The **H**ENSLEY **E**NGINEERING **G**ROUP

July 18, 2014

Re: Sevano Place Subdivision – Drainage Report

We are resubmitting the attached report in support of the Site Development Plan of Sevano Place Subdivision.

Sheet Title  
**MASTER GRADING AND DRAINAGE PLAN**  
Date  
**MAY 2, 2014**  
Project No.

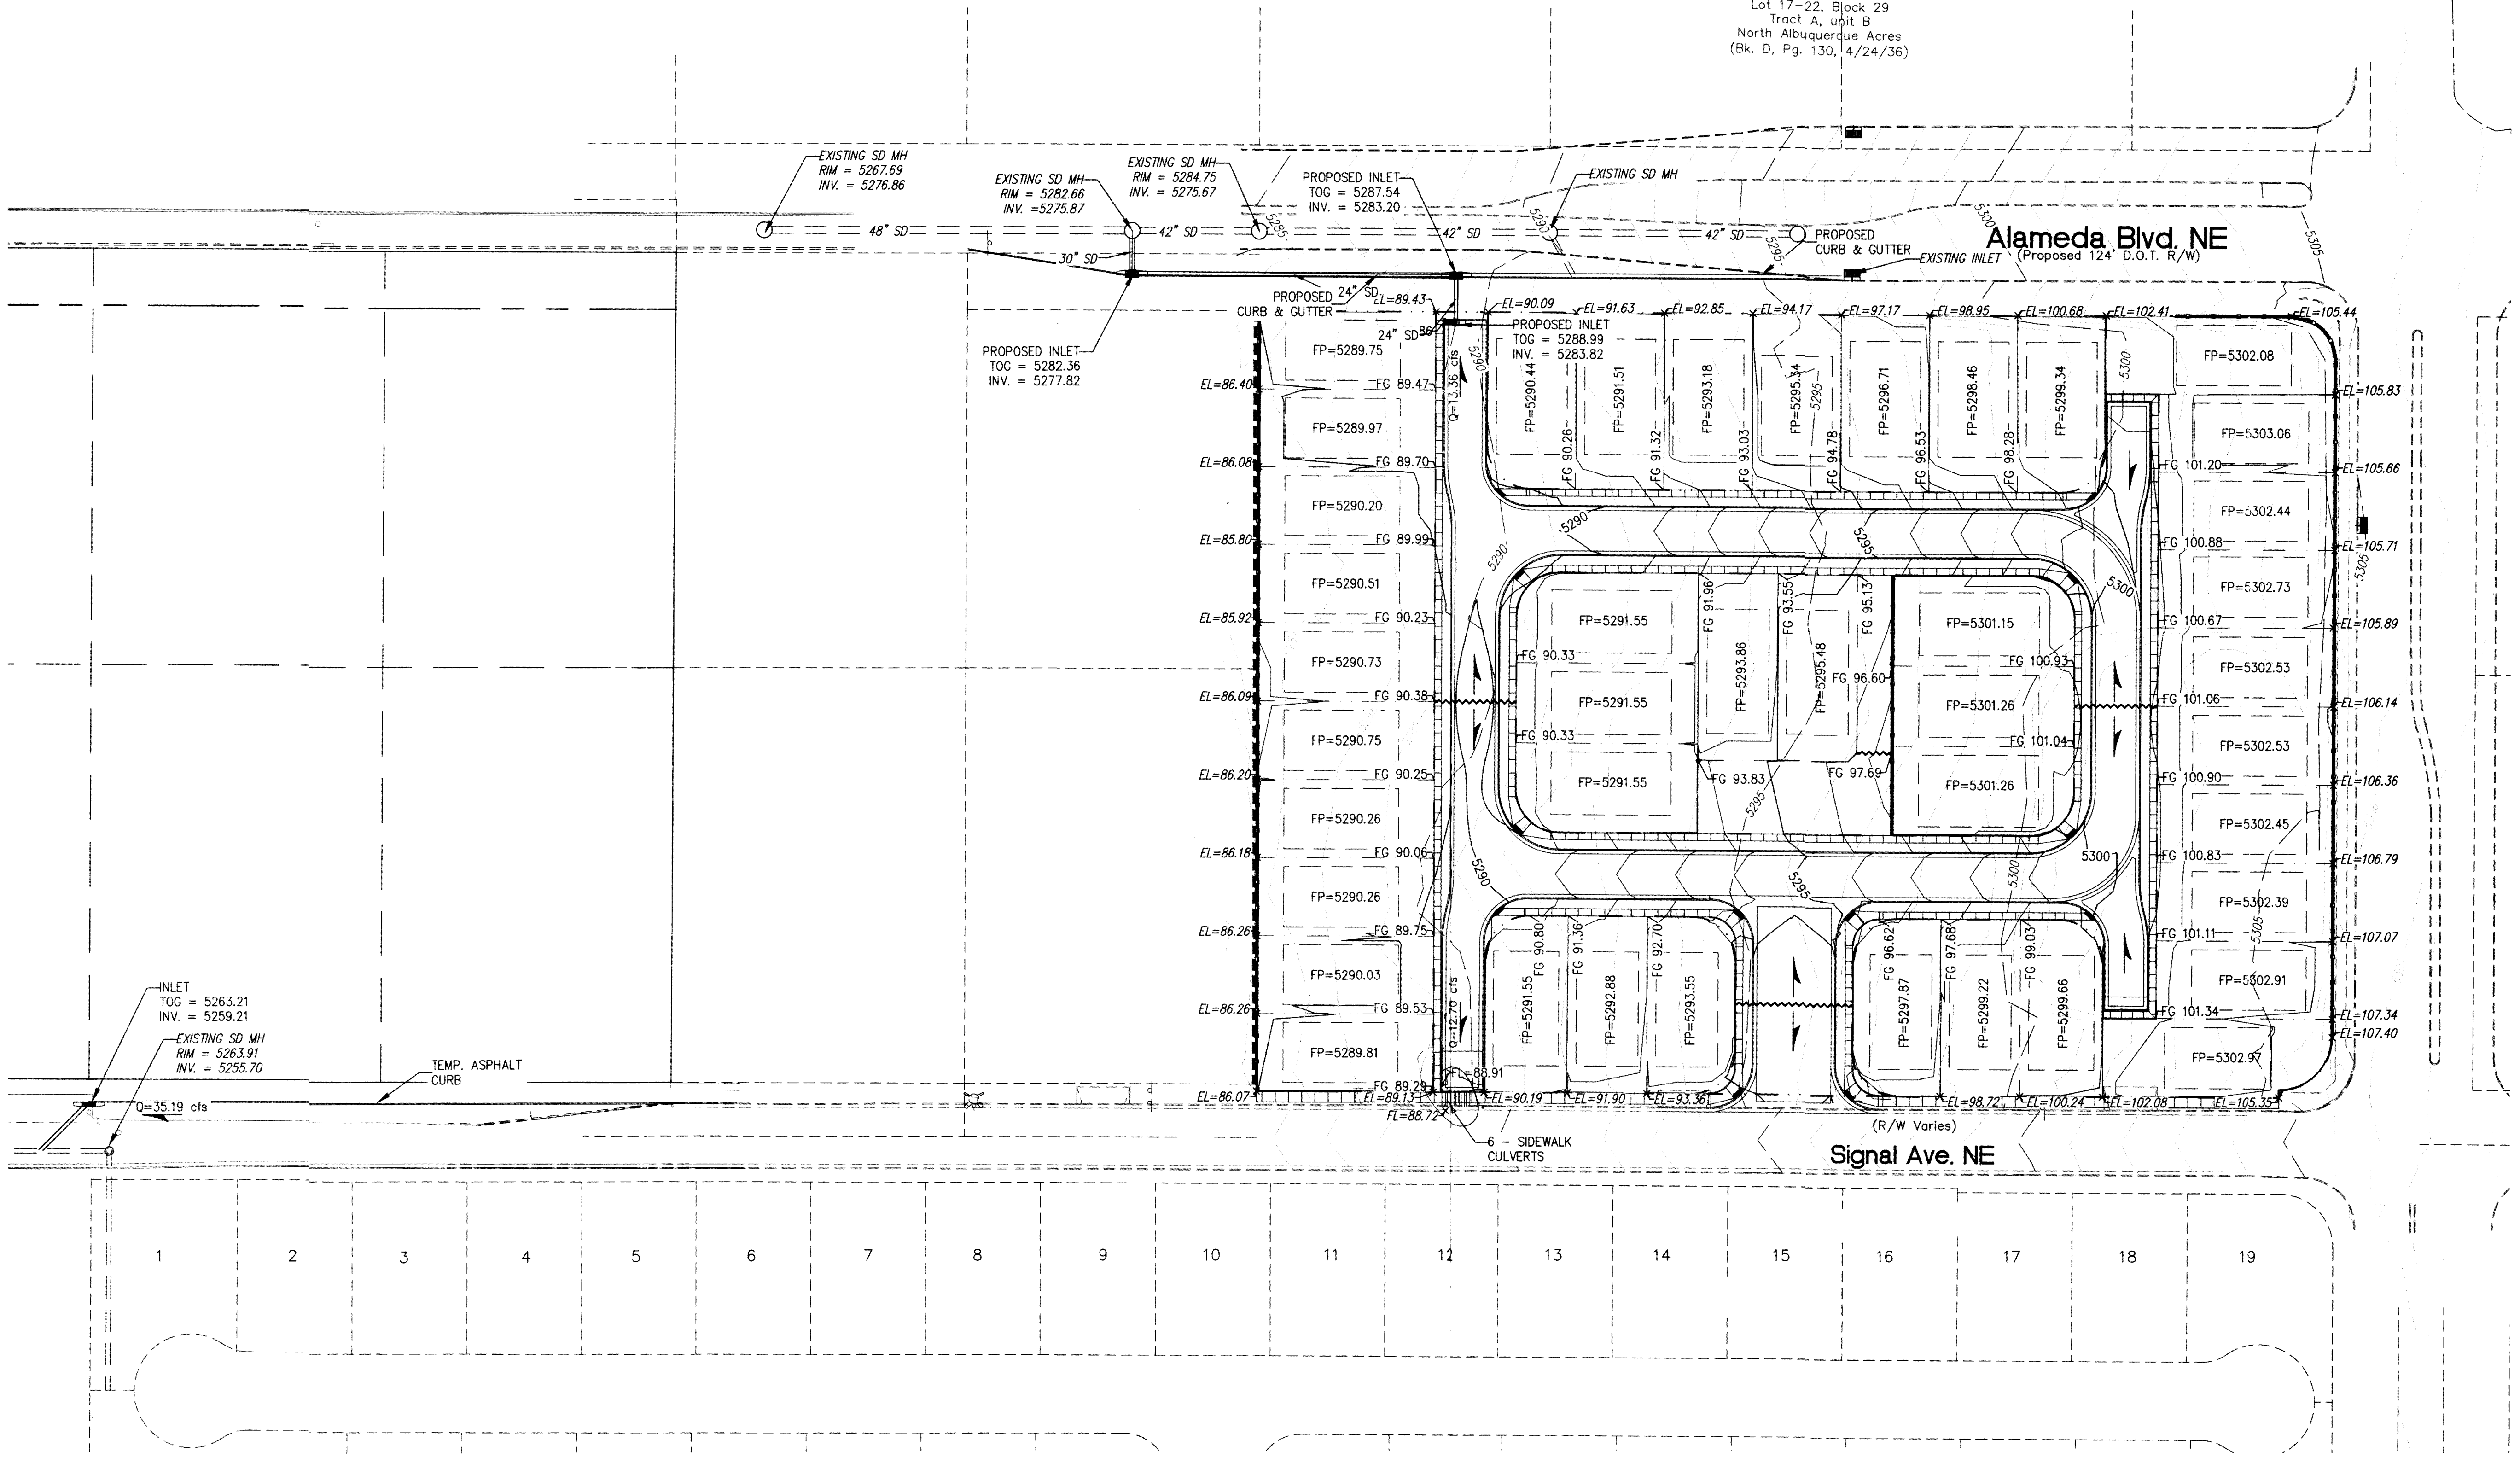
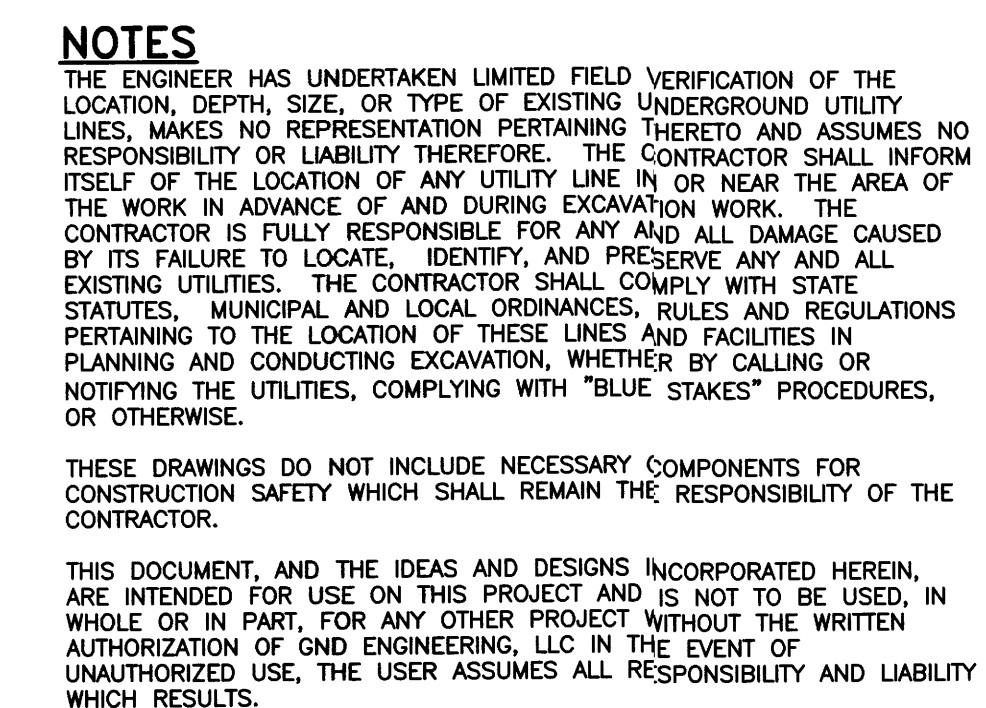
The comments of July 14, 2014 have been addressed with the following:

- The Grading Plan has been modified to include a retention area on each lot to accommodate first flush.
- The AHYMO reports for the 6 and 24 hour storms have been included in the report

- The Grading Plan has been modified to reduce the number of sidewalk culverts to 2 and the street has been super-elevated toward drain at both outlet points. There will be openings to the adjacent ROW to accommodate emergency overflow at discharge points.

- The driveway positions of lots 1 and 10 will not be effected by the water depth as shown on the grading plan.
- Temporary asphalt is depicted on sheet 2.

- The inlet in Signal is a Type A.
- The retaining wall has been extended to the north side of lot 18.
- The sidewalk on Alameda has been corrected.
- The table on p. 4 has been revised.
